Office of Water

Our ref : ER20900
Your ref: MP10_0177 Mod 2

**MP 10_0177 MOD 2 – Modification of approval – Stage 1 project application
Residential and child care development – 14-18 Boondah Road, Warriewood**

TYPICAL SECTION BIORETENTION
BASIN A
SECTION 1
1: 50 75W C240

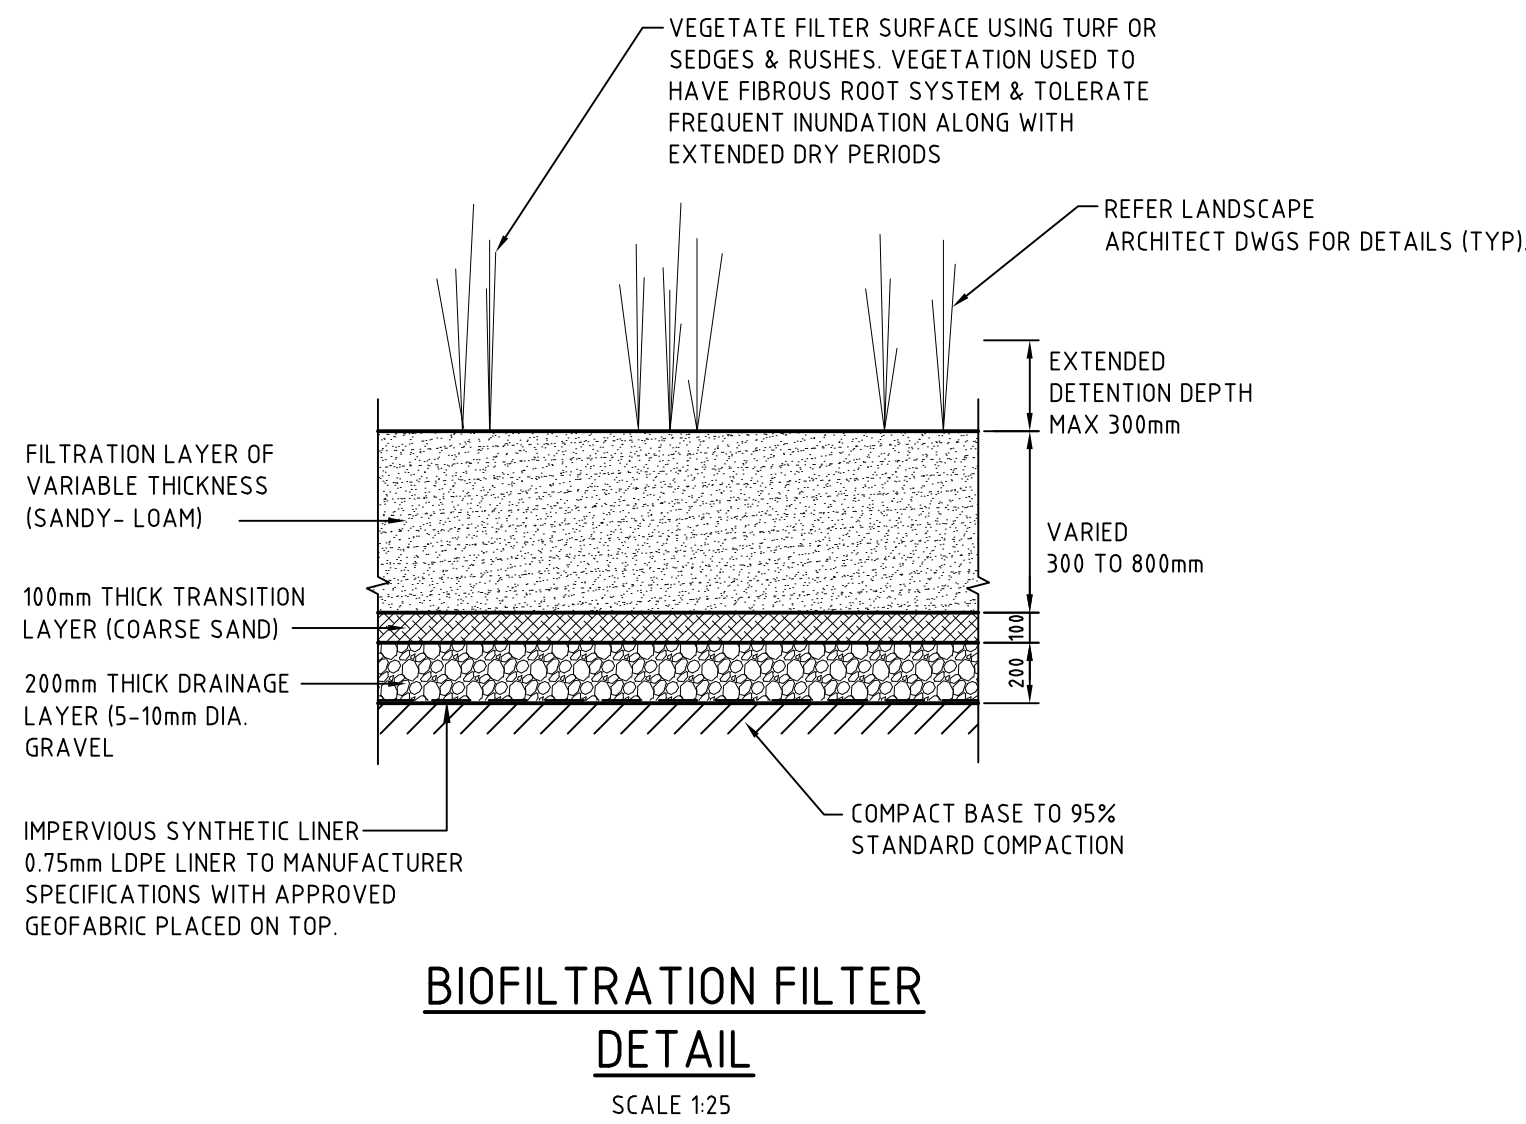
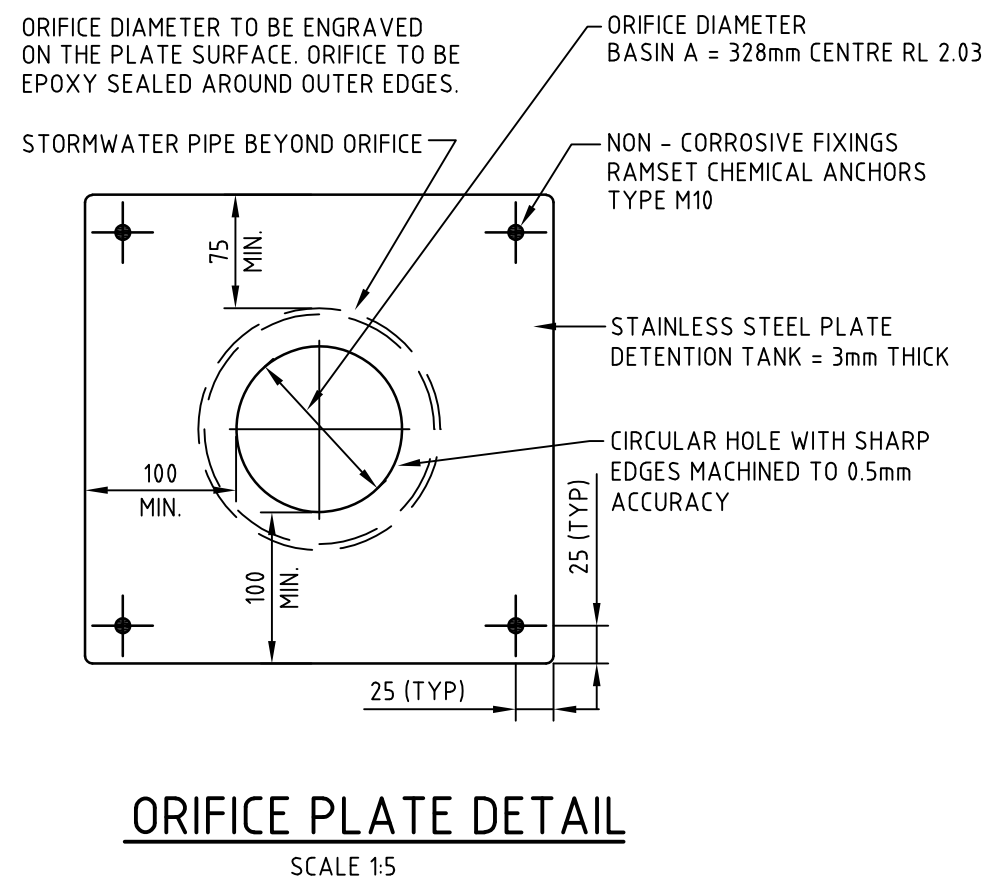
The Hydrogeological Report (dated 2 March 2011) indicates that during construction the groundwater flows would be pumped to the Bio-retention Basin A and from this basin there will be controlled discharge to the Warriewood wetlands (page 7). The report indicates that depending on the quality, treatment may be required. In relation to the operation phase of the development, no details have been provided as to whether it is also proposed to pump water from the basement to the detention basin and discharge to the wetland. No assessment has been provided on the impacts of discharging potentially contaminated groundwater from the basement area to the wetland or any proposed treatment of this water.

The applicant needs to demonstrate that the proposed modification will not adversely affect the Warriewood wetlands and that the discharge of potentially contaminated

groundwater of below ground areas will not degrade the wetlands, meet the National Water Quality Management Strategy ANZECC guidelines for Aquatic Ecosystems and the water quality objectives for the receiving waters. Otherwise the approved conditions in relation to this project need to remain.

Based on the information provided with the modification, NOW can not support the proposed amendment to the existing Condition C19a to permit intermittent dewatering of the basement carpark. The existing Condition C19a is still relevant to the proposal.
